BCA Assessment Report

Proposed Multi Level Warehouse Facility
49 Stephen Rd. Banksmeadow, NSW 2019

Revision 5

21 October 2024

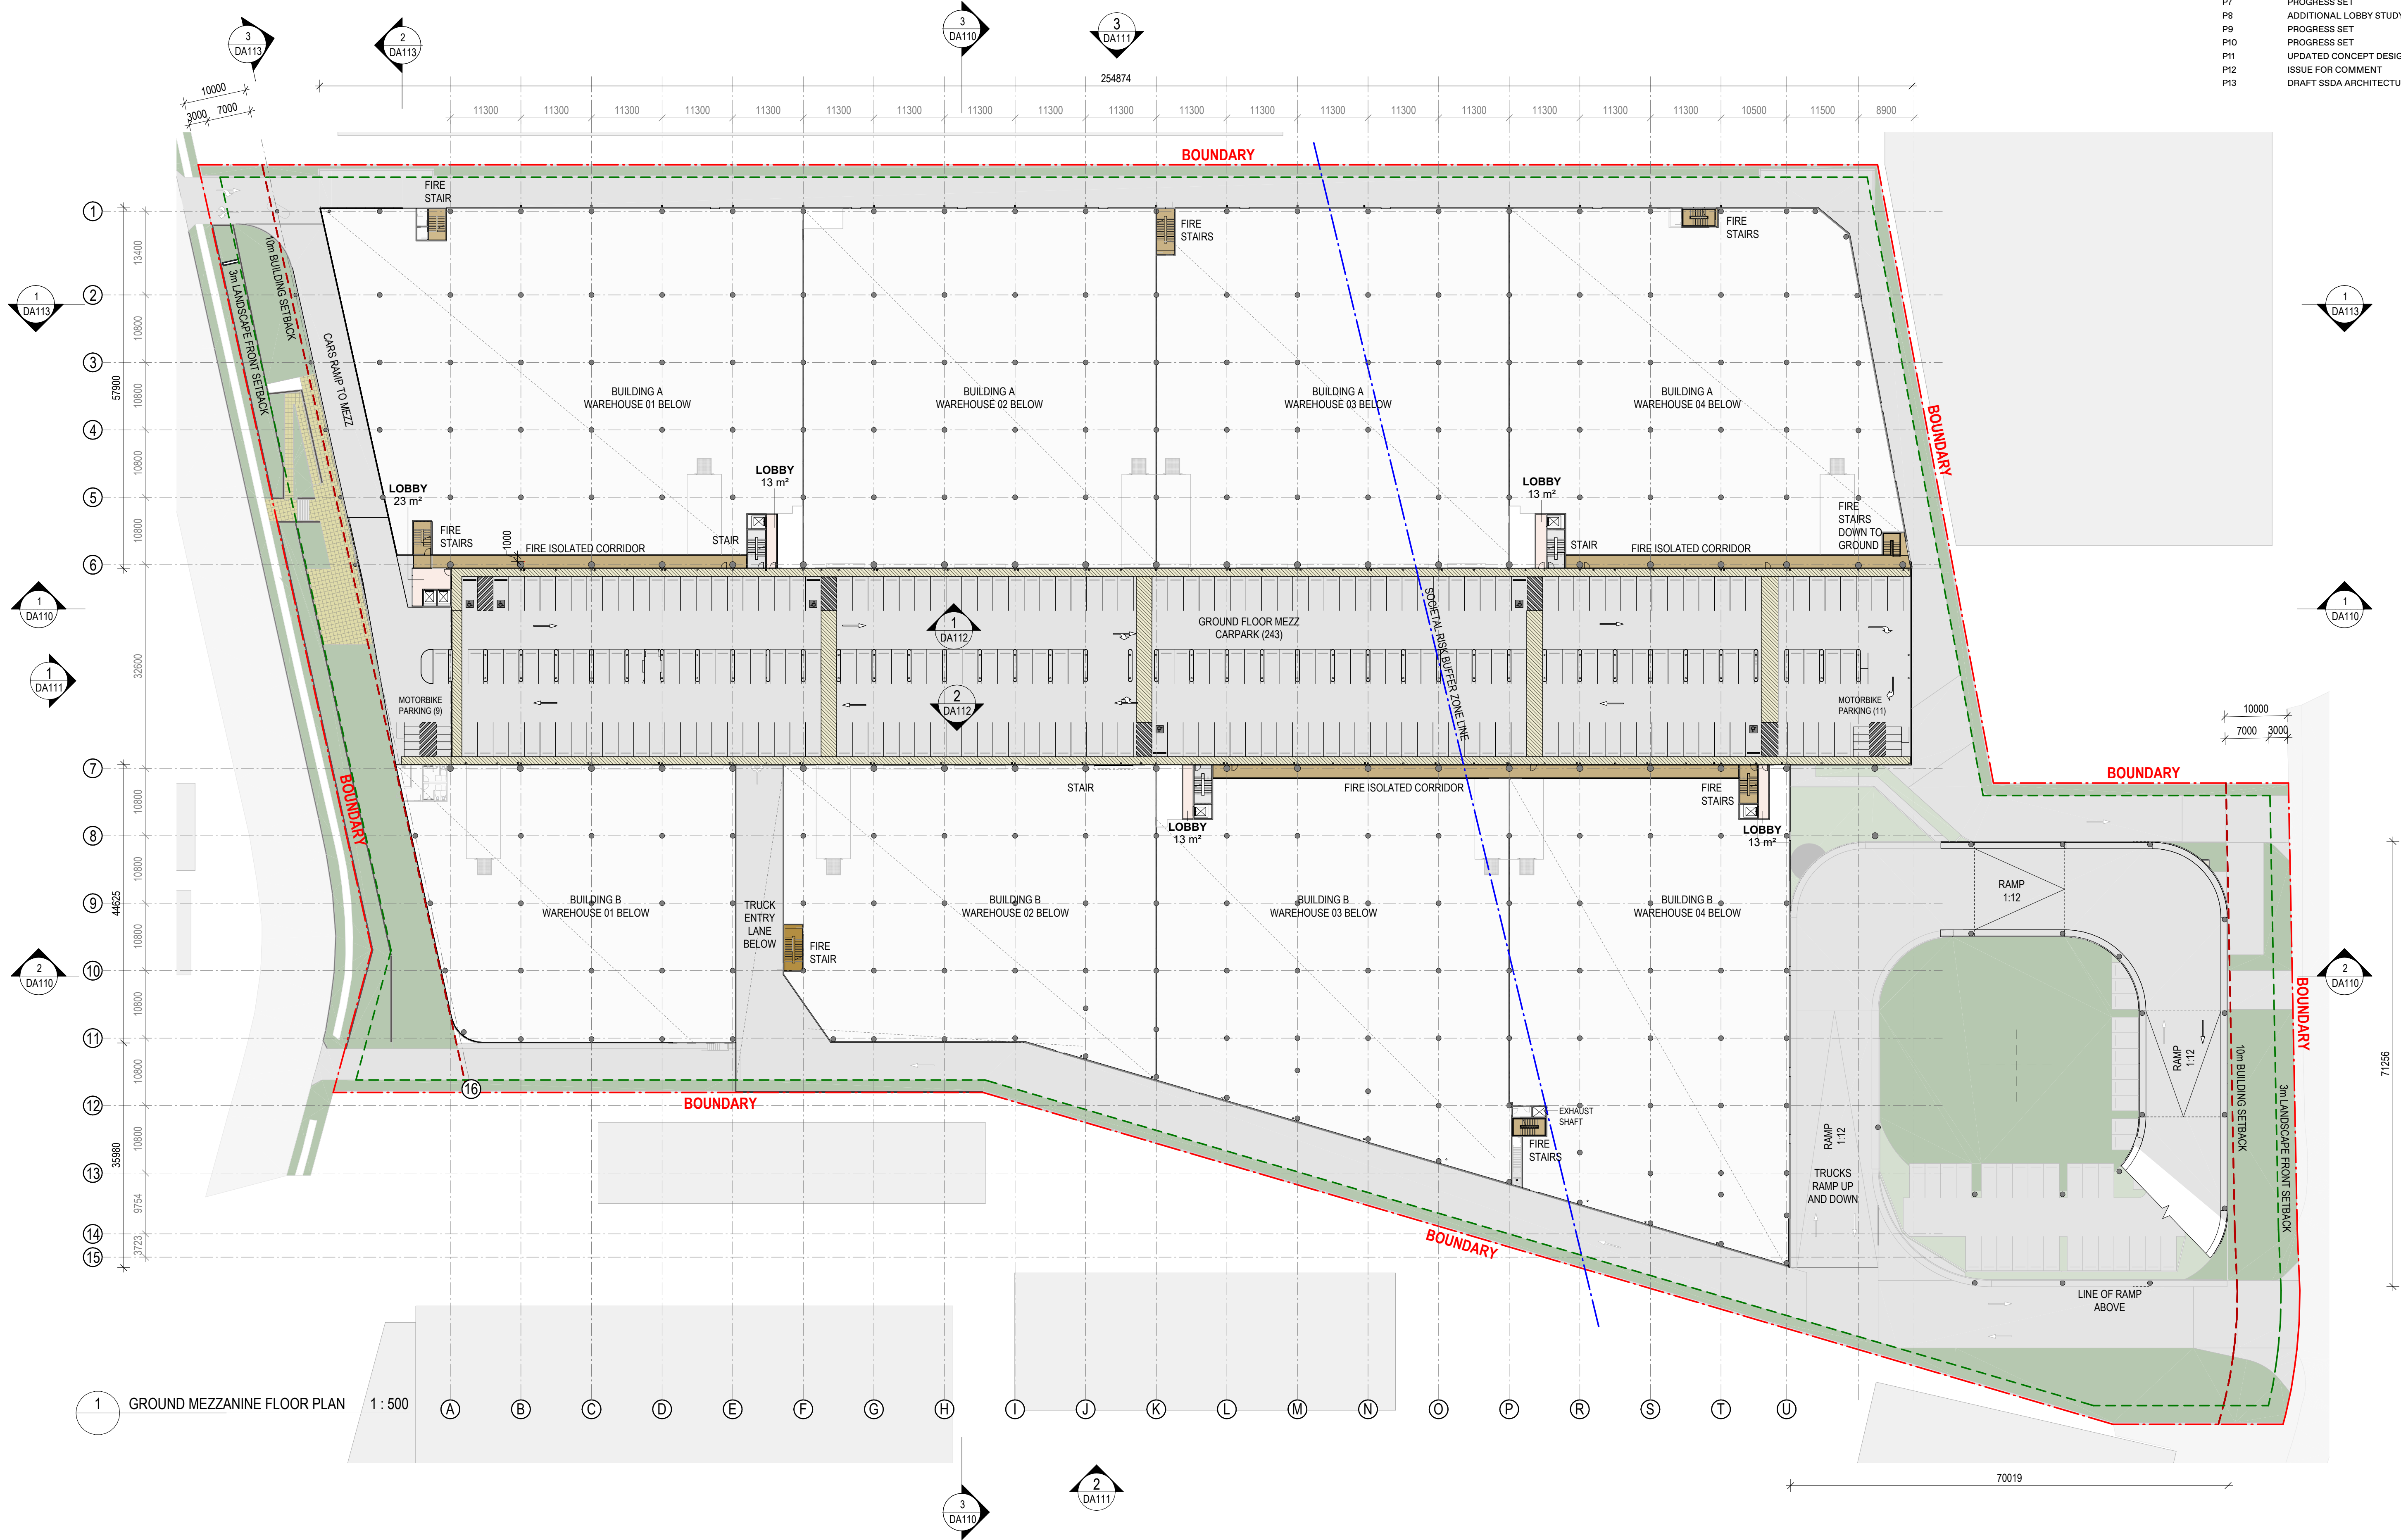
6. D3D25 & D3D26	The egress gate at the main entry is to swing in the direction of egress. This door is to be openable from the inside at all times or is to unlock upon fire trip.

2. C3D5	A performance solution is required to address the Perimeter Vehicular Access where the path is further from the buildings than what is permitted under the DtS provisions and where there is a localised reduction in width to the accessway.

1 WEST ELEVATION - WAREHOUSE 1 : 500

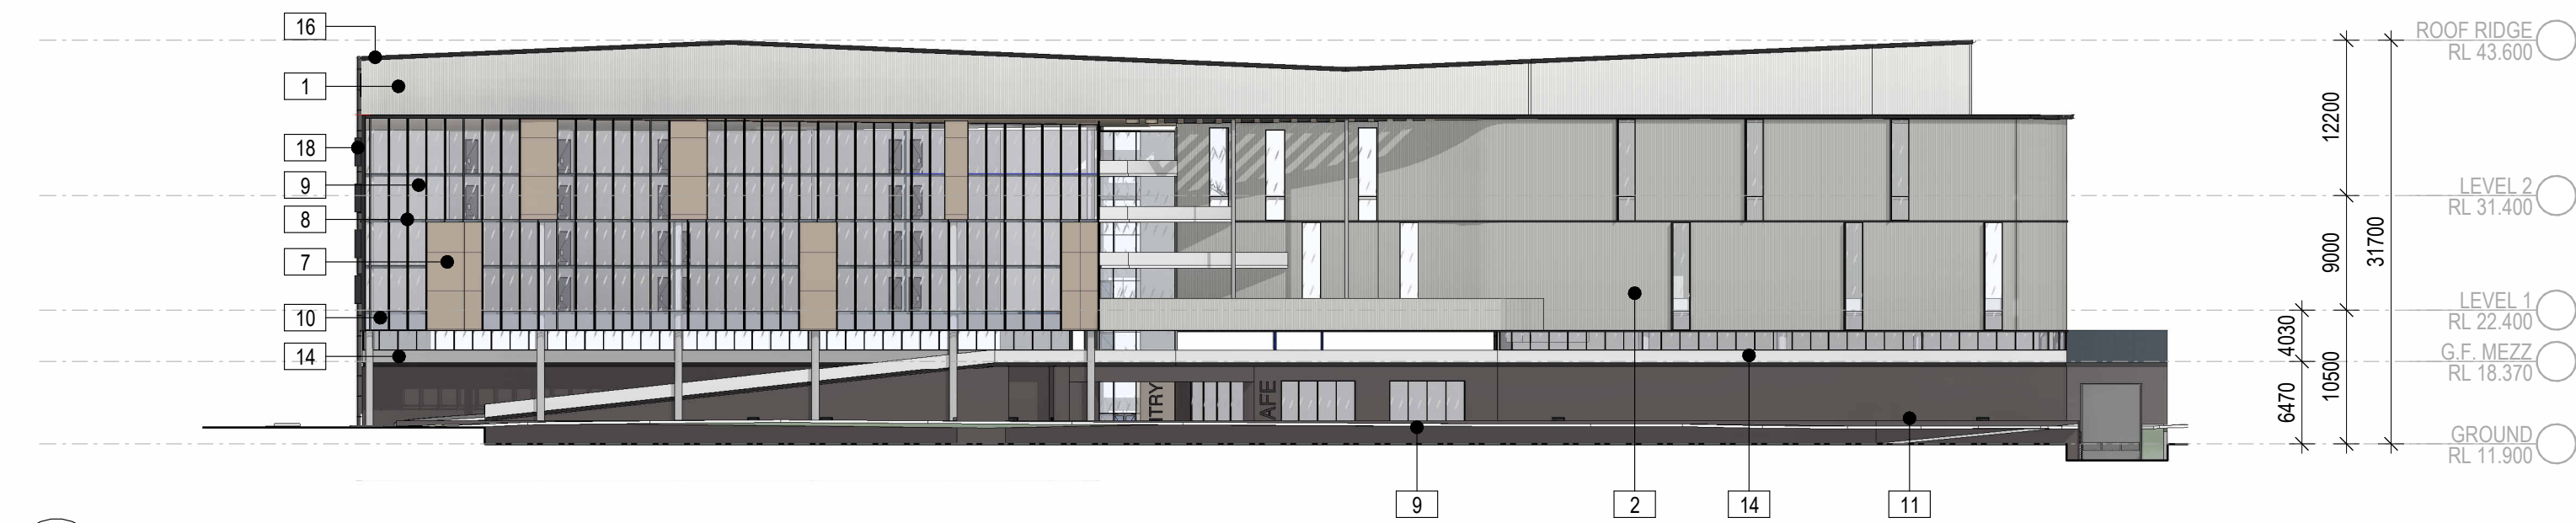
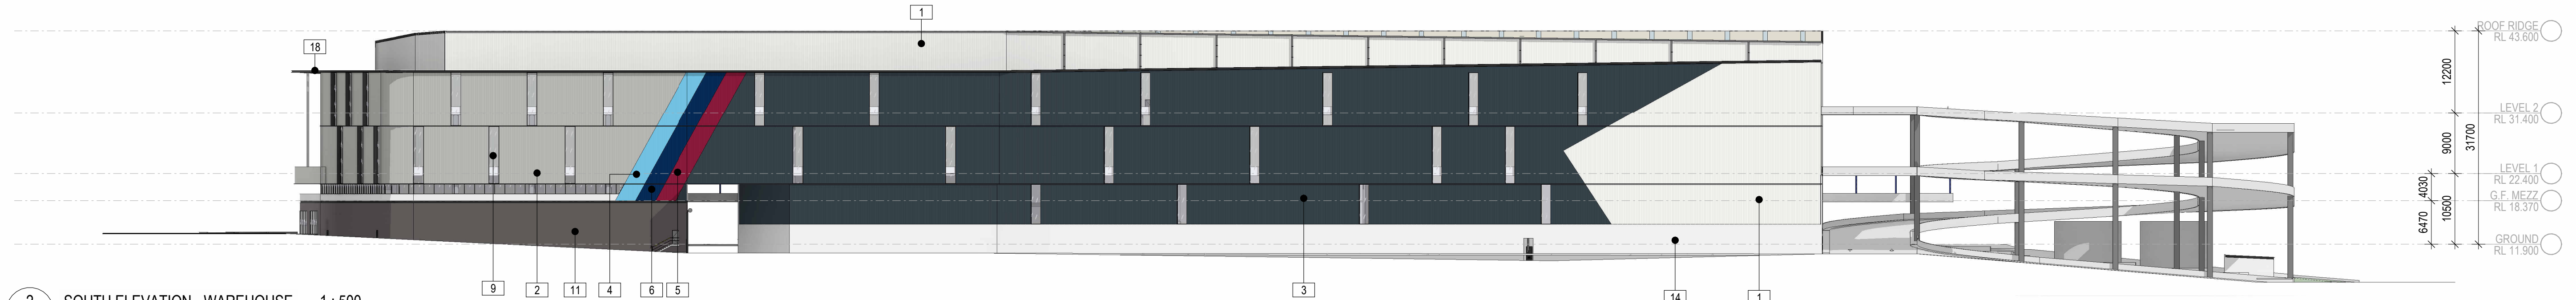
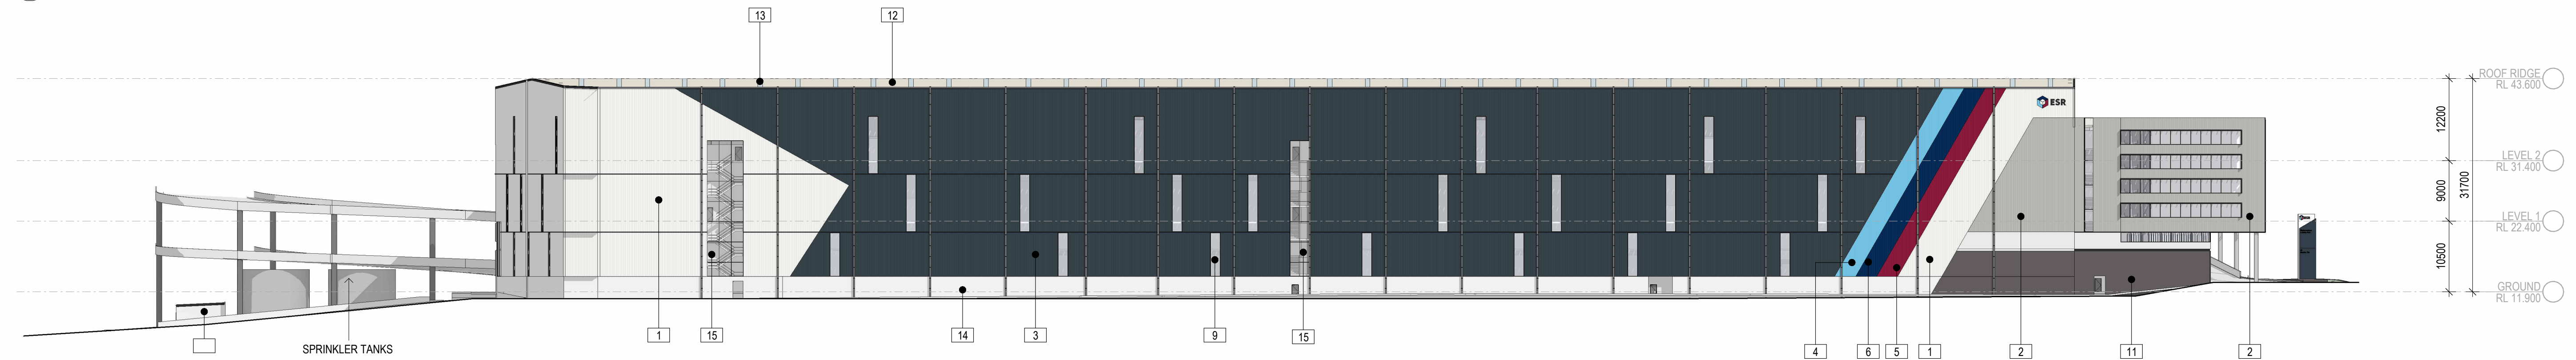
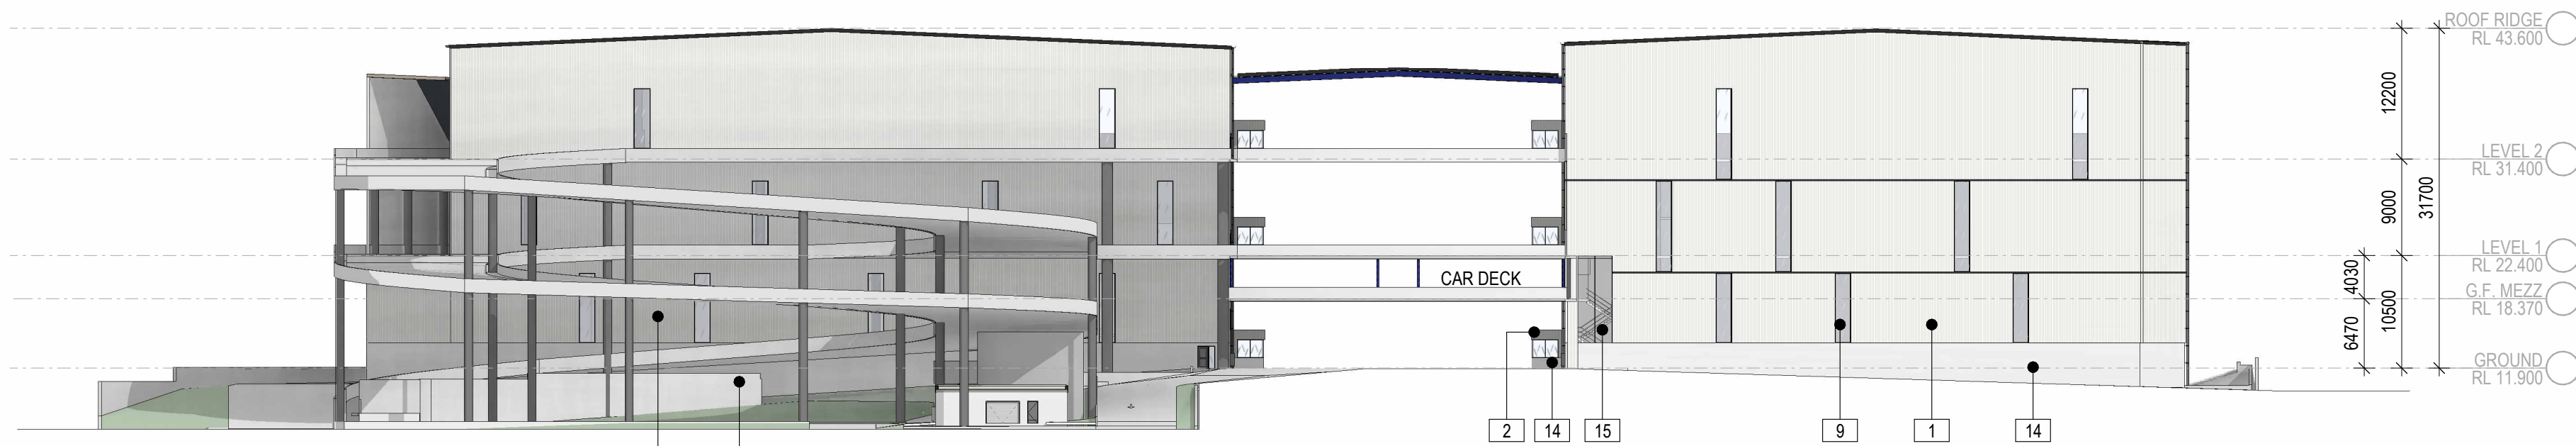
+ BCA (DtS) Clause	+ Description
1. C2D10 & C2D14	Details of the non-combustible external walls, including all ancillary elements and attachments, to the Offices and Warehouses are required to be provided for assessment.

1 GROUND FLOOR - END OF TRIP FACILITIES 1 : 150

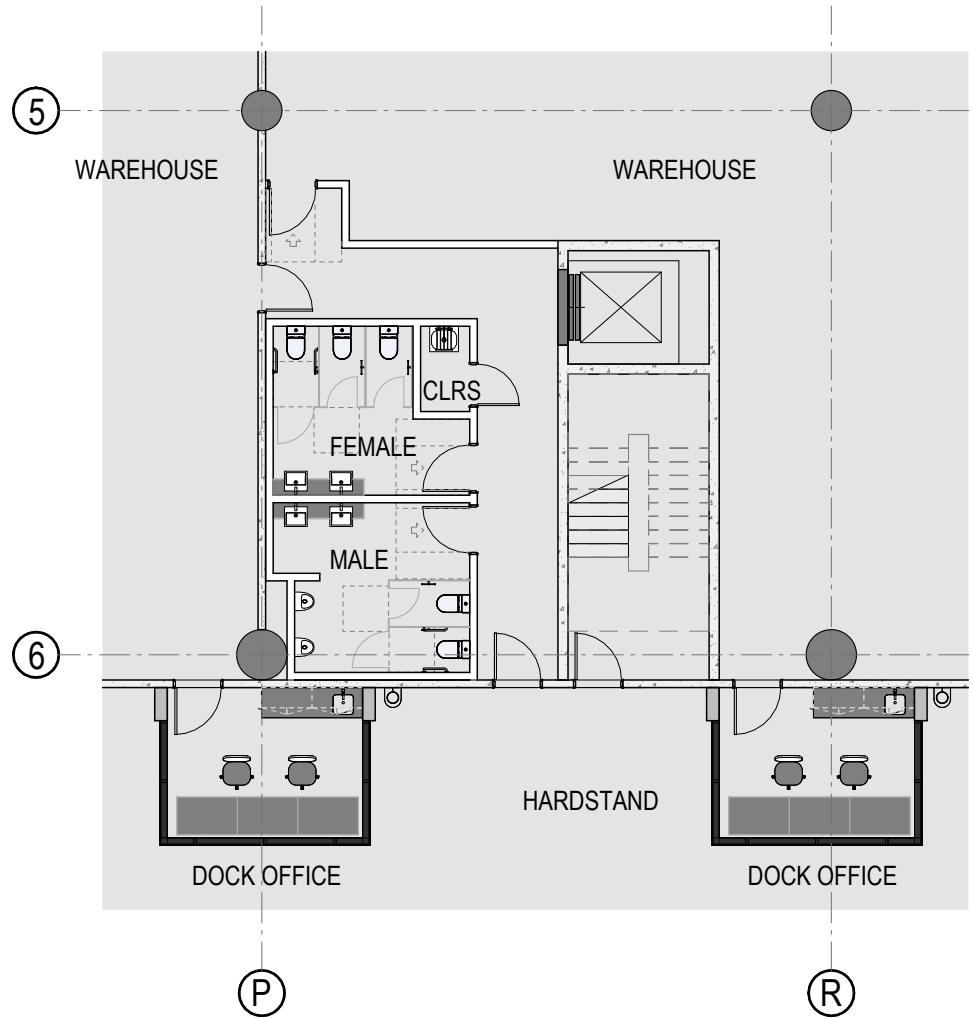
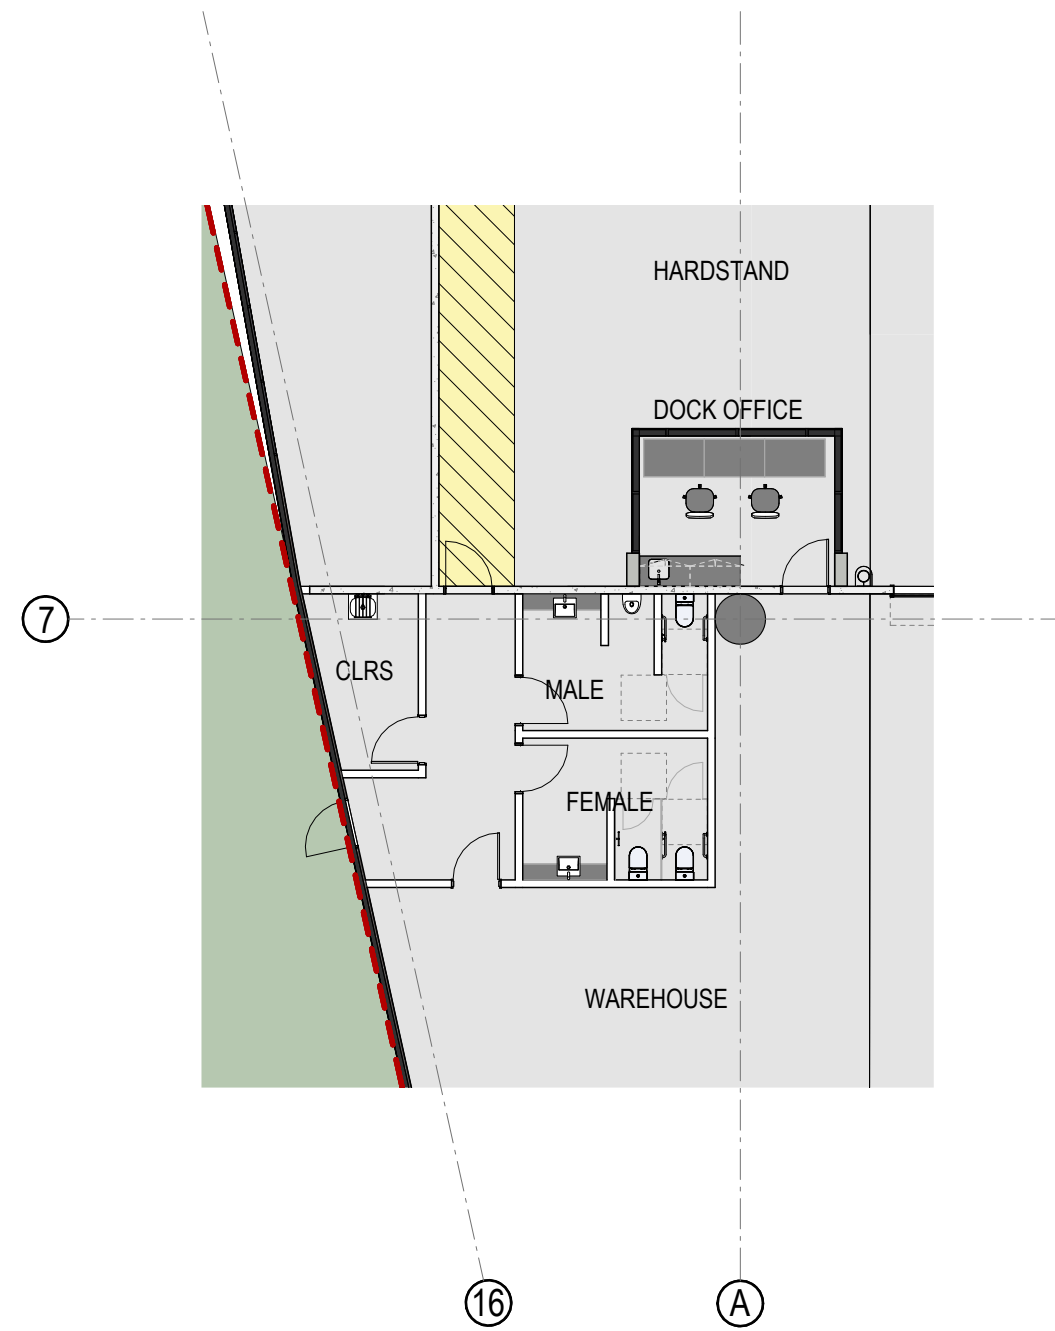
11. F4D4	The required number of sanitary facilities have been provided for each warehouse and office level in the report below. These numbers may be revised once confirmation on population numbers have been provided by ESR. Sanitary facilities reflecting compliant numbers are to also be nominated on the plans.
